OUT17/11059

**Modification 3 to Belle O'Connor Street Residential Subdivision (MP 08_0167 MOD 3)
Comment on the Statement of Environmental Effects (SEE)**

Mitchell Isaacs
Director, Planning Policy & Assessment Advice
17 March 2017

Figure 11: Proposed Stormwater Management Features within SLD (source: PPR)

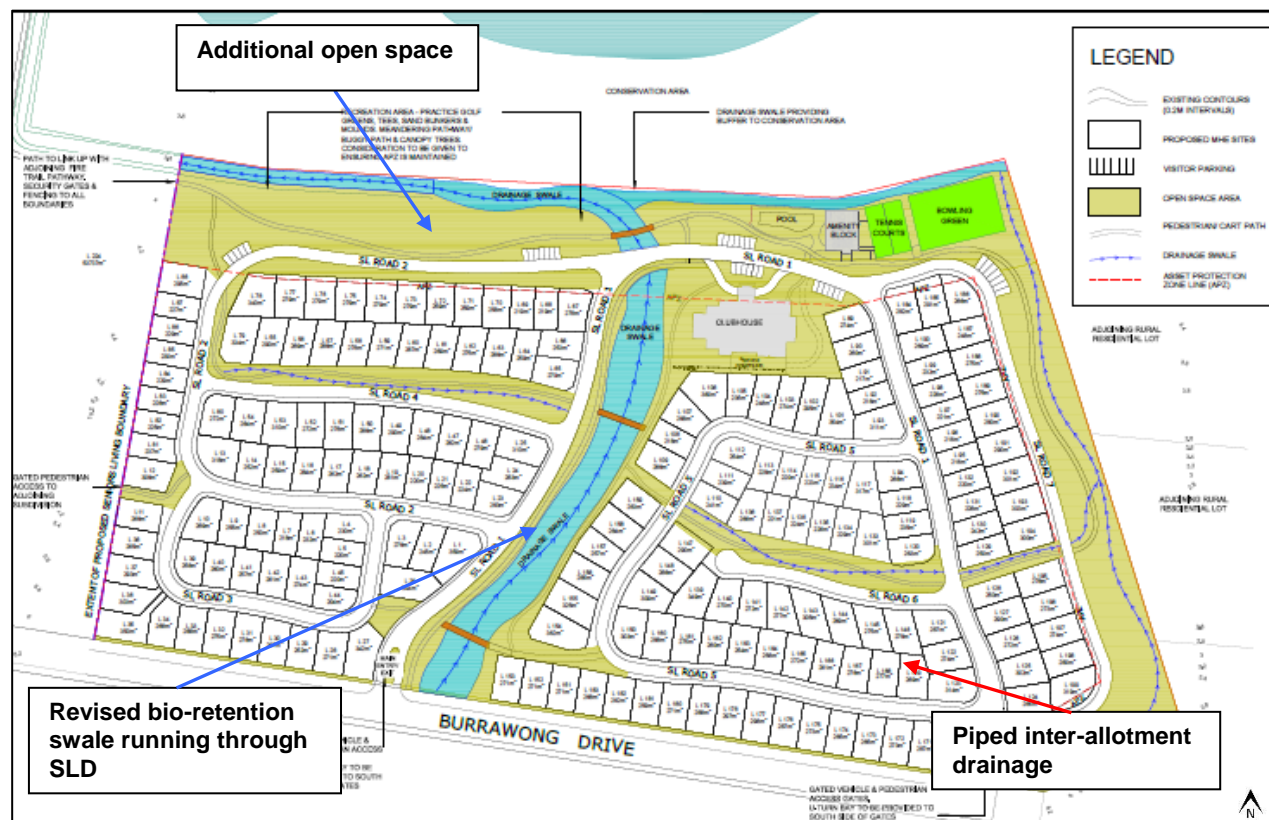
- The Landscape Plan (Appendix F) depicts a drainage swale at the northern boundary. It is unclear whether this is proposing a variation to the approved bioretention swale in this area, however its shape and design appear different. The Landscape Plan (Appendix F) and Section 5.5 of the SEE depicts the modified drainage system which includes the central north-south swale and an east-west swale. DPI Water is supportive of maintaining the structure and functioning of the bioretention swale as originally currently approved, including the vegetative structure as approved in Mod 1, which included macrophytes and broad leaved native plants.. Clarification is therefore requested.

- DPI Water is supportive of these swales to maintain the vegetative structure as approved in Mod 1, which included macrophytes and broad leaved native plants. Clarification is requested that this structure is to be maintained.
